DOC21/1057302

1 December 2021

**Sydney Metro West – The Bays to Sydney CBD (SSI 19238057)
Advice on Environmental Impact Statement (EIS)**

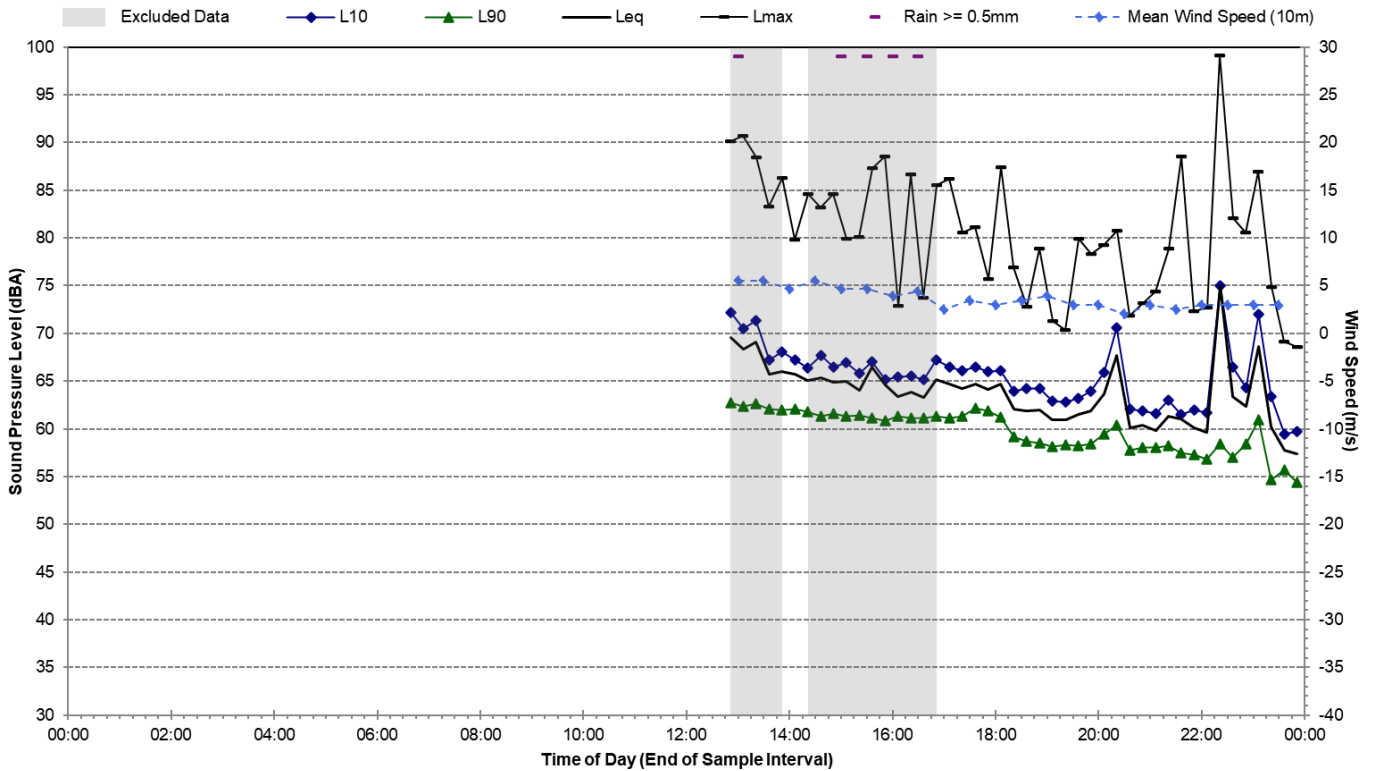
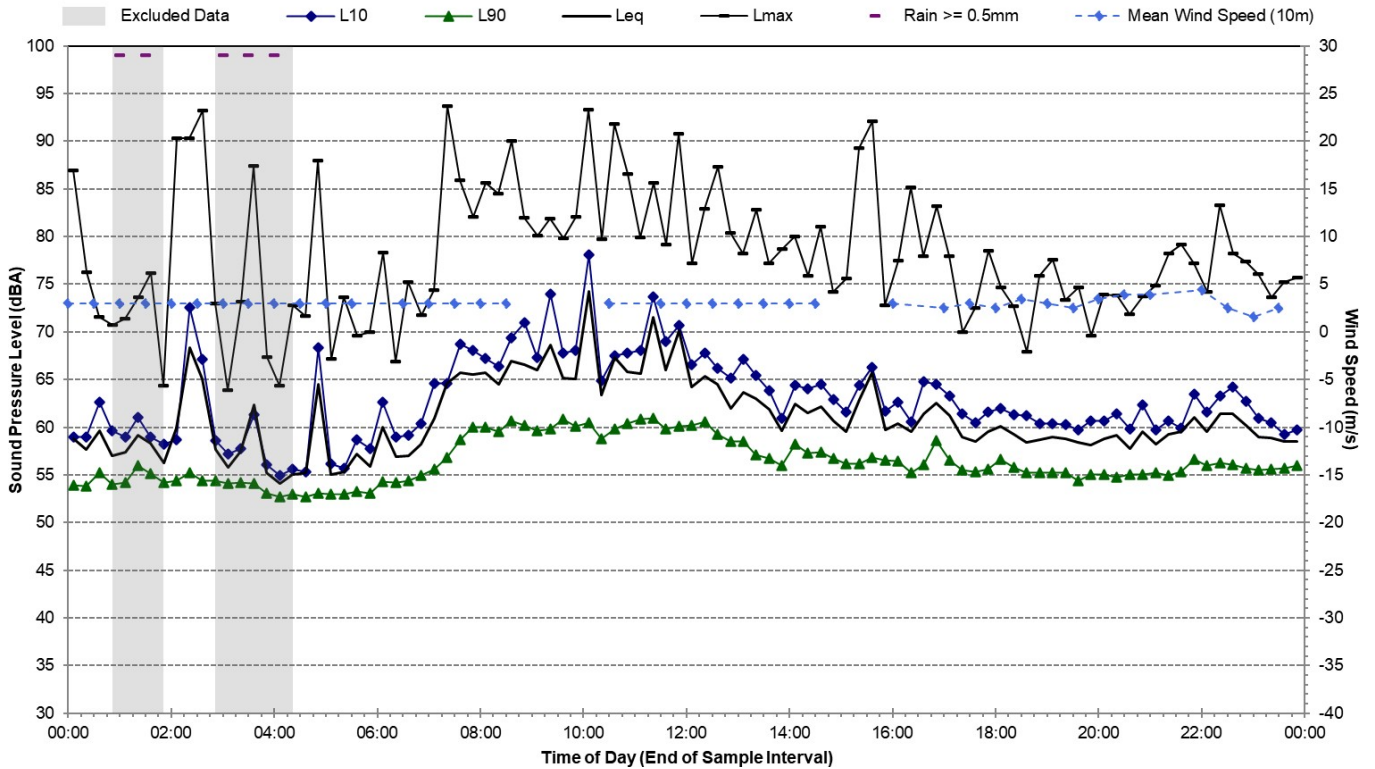
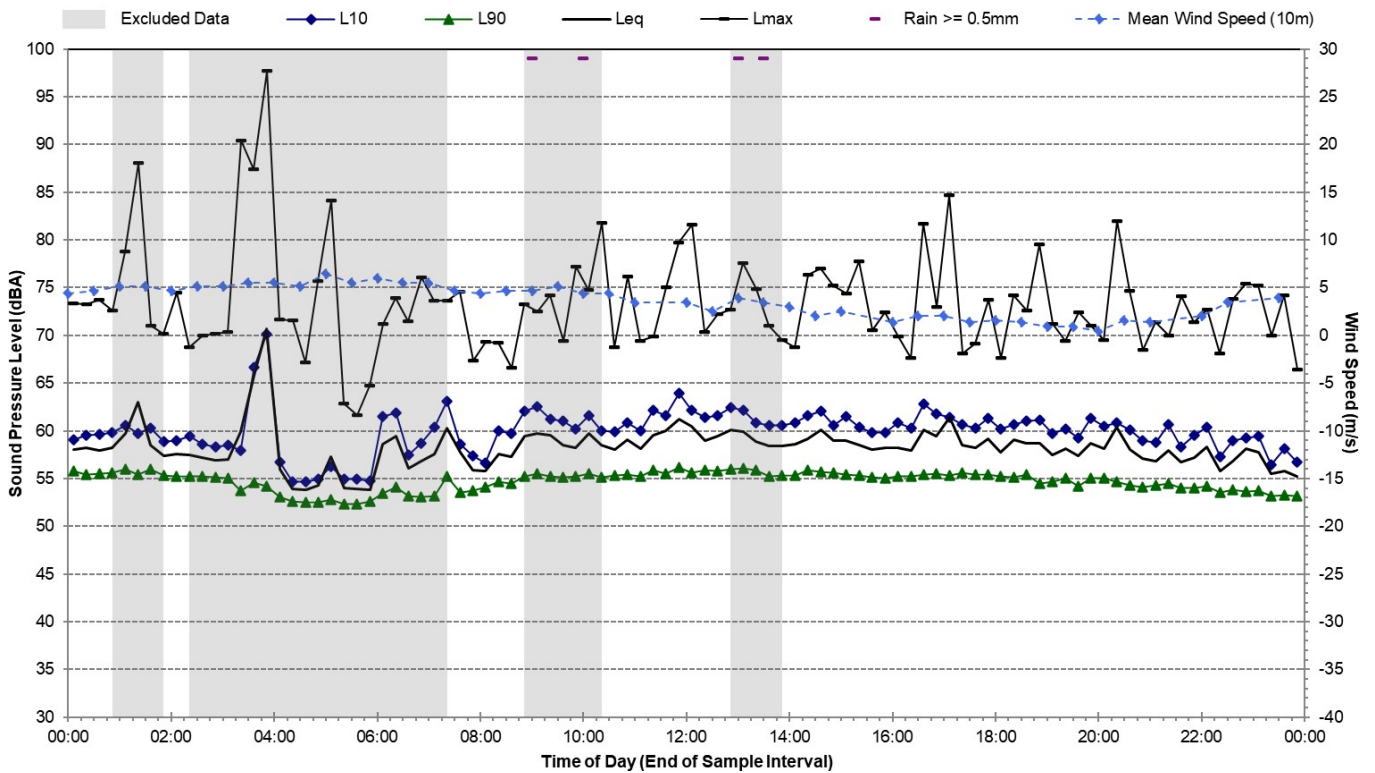
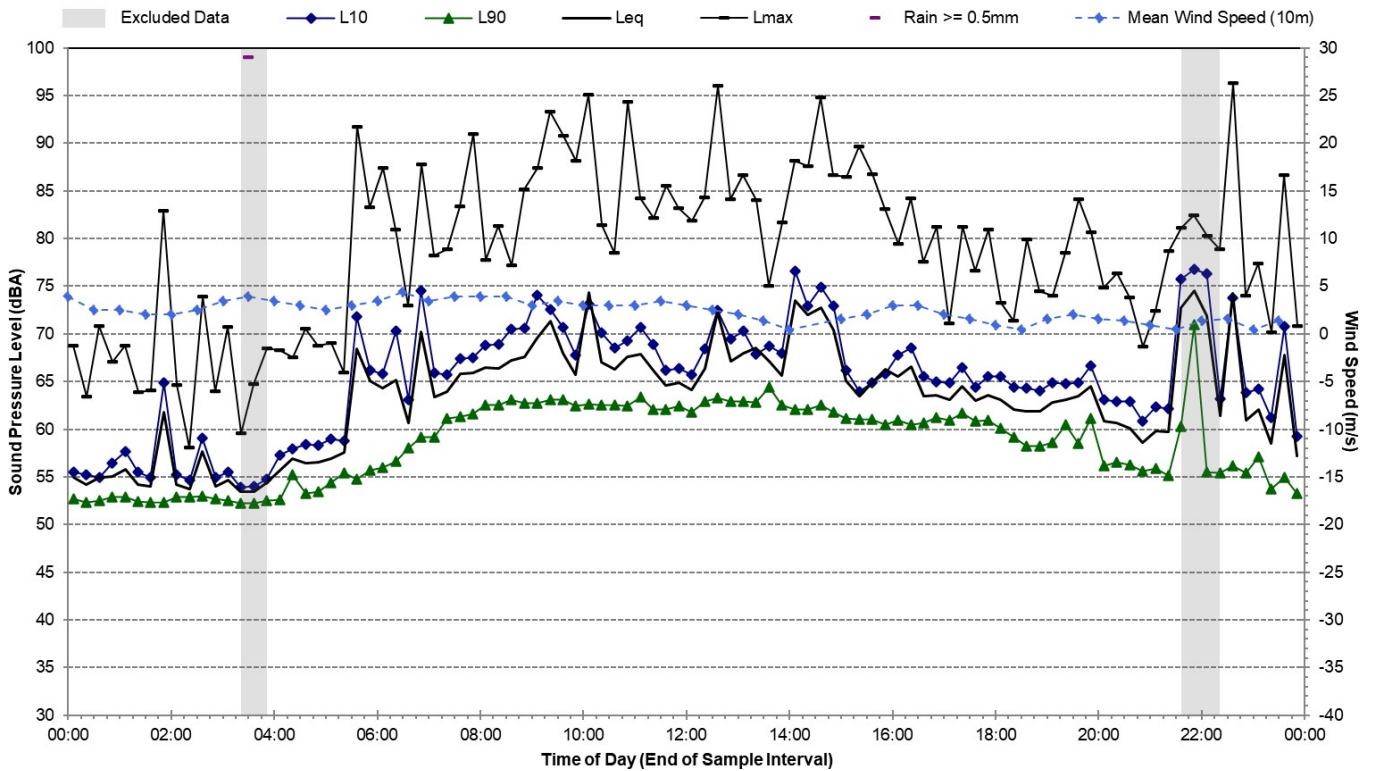
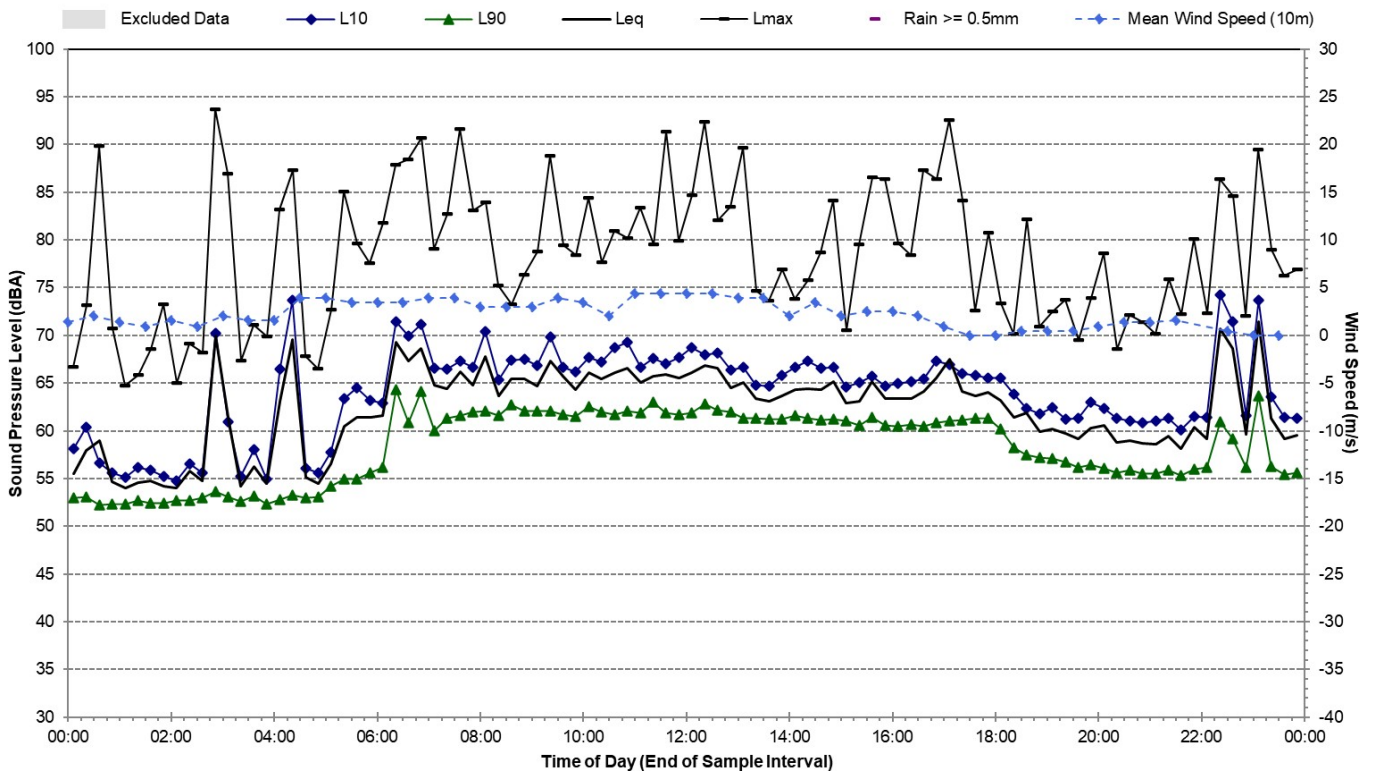
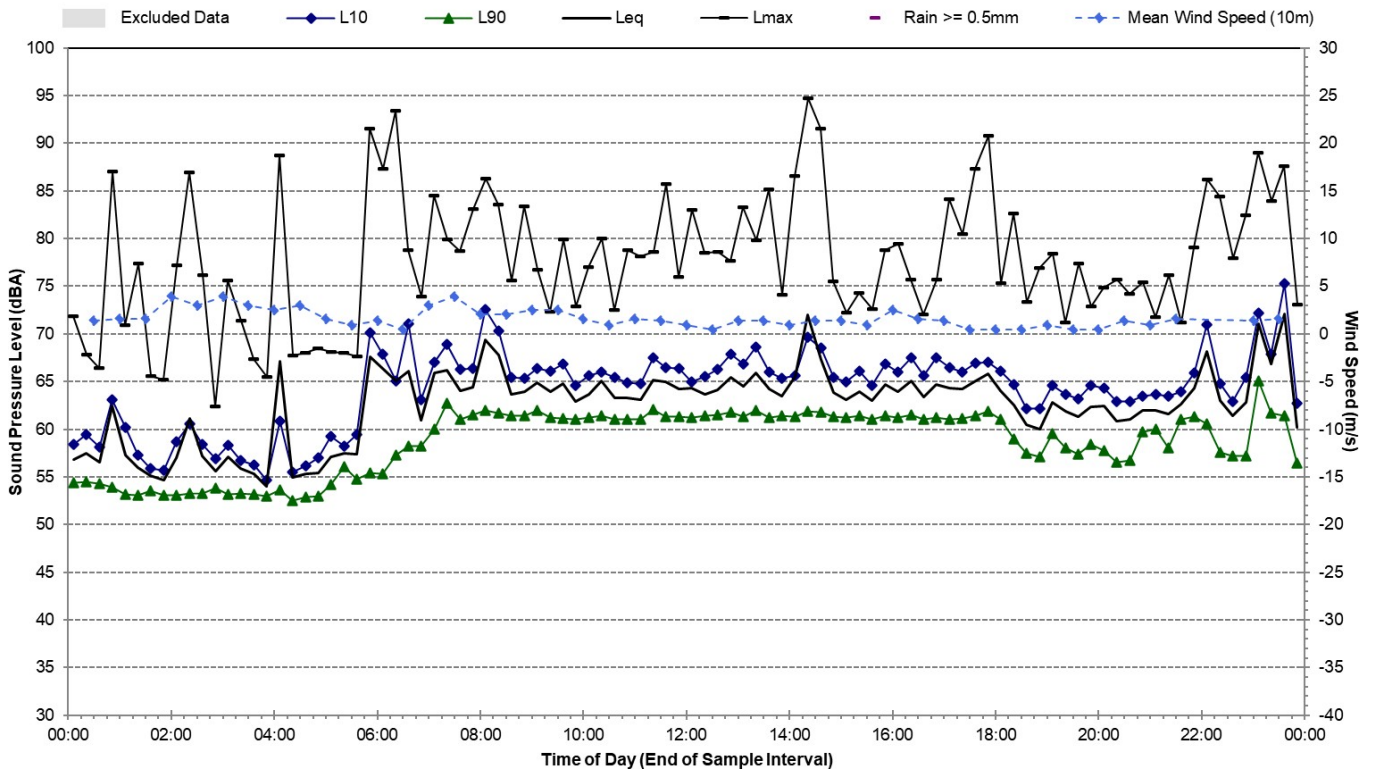
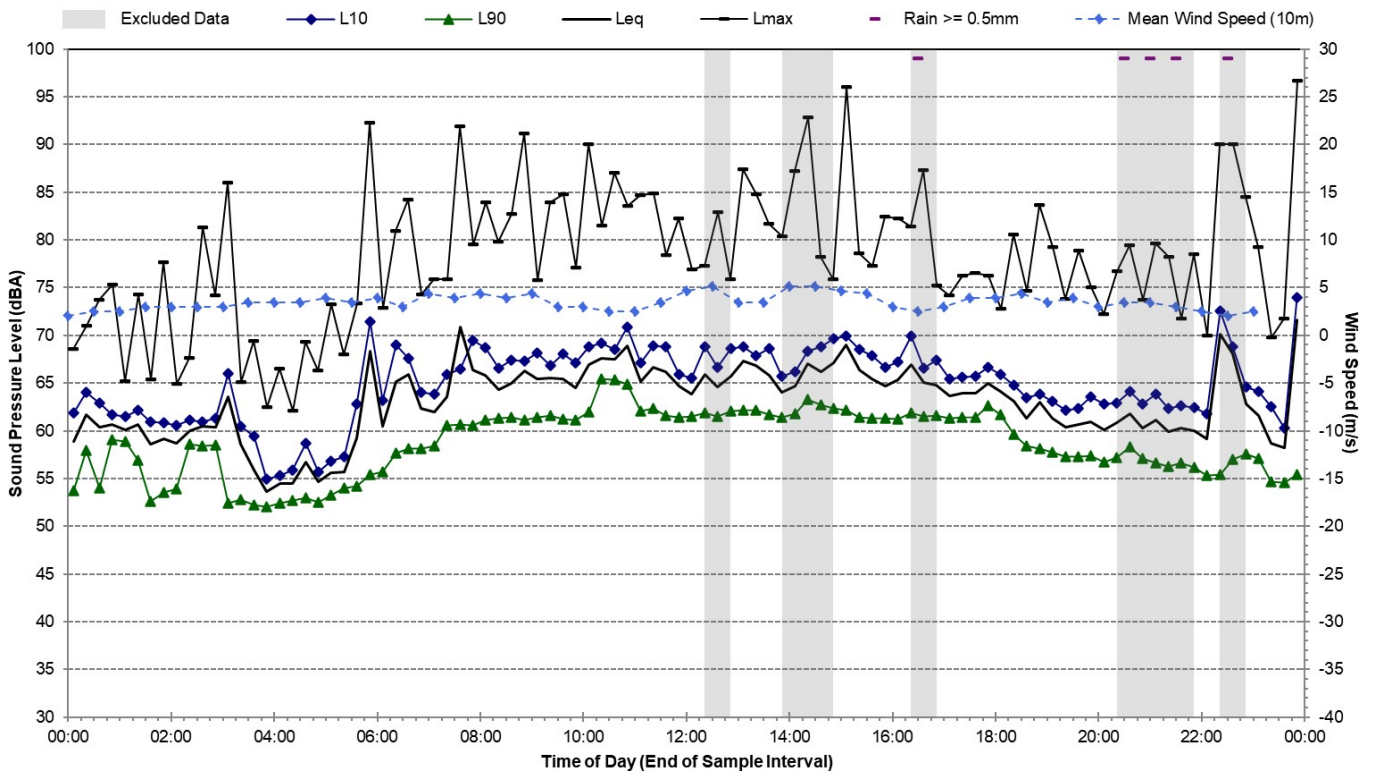
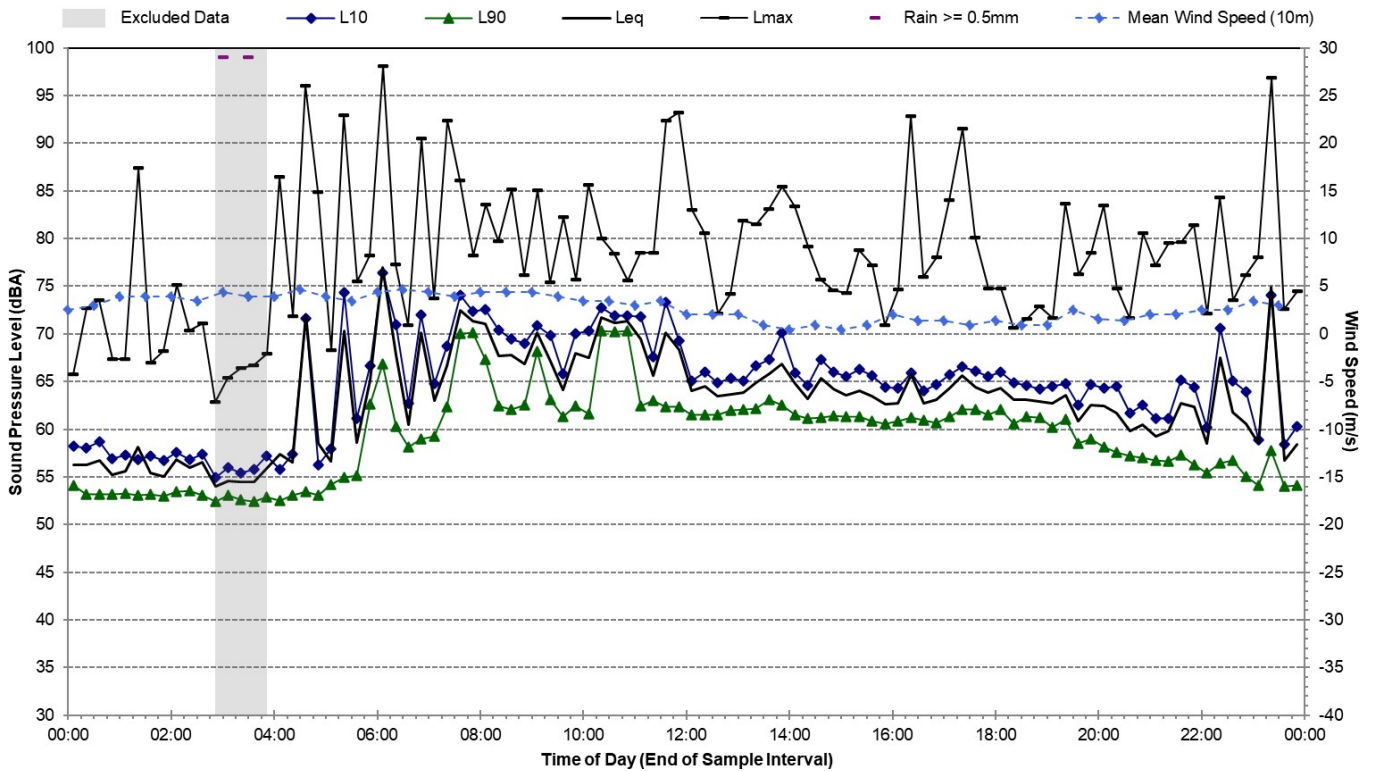
- The monitoring at Location B.06 was noted in Appendix B of the NVIA to have its background noise level affected by nearby mechanical plant.

The EPA recommends that the proponent clarifies to what extent this mechanical plant affected the measurements and whether the noise monitoring data at Location B.06 is representative of background levels in the NCA.

- Furthermore, it appears that the monitoring equipment at Location B.06 was located on a balcony and there is potential for it to be affected by façade reflections. Since RBLs are a free-field noise level, any correction made for façade reflection should be stated in the NVIA.

The EPA recommends that the façade reflection status of all background noise measurements is included in the NVIA and any adjustments made to the measured noise levels reported and justified.

- The information supplied for monitoring Location B.06 is not consistent within the NVIA. Page 43 (of 70) of the NVIA Appendix B document gives the address as 1 Hosking Place and dates between 2 May 2019 and 20 May 2019, however the graphs that follow have dates in June 2015 and the address as 1 Harwood Place.

The EPA recommends that the proponent clarifies addresses and dates for all monitoring locations.

- Monitoring graphs in Appendix B of the NVIA appear to report the wind speed at 1.5 metres. The meteorological data for all locations appears to have been sourced from the Bureau of Meteorology station at Observatory Hill. It is not clear how wind speeds were converted from the height of station to 1.5 metres and also how the wind speed was calculated at the monitoring location on the balcony at Location B.06.

The EPA recommends that the NVIA includes the method and assumptions used to convert wind speeds to 1.5 metres, and the height of the microphones above 1.5 metres from ground level and a justification it is appropriate.
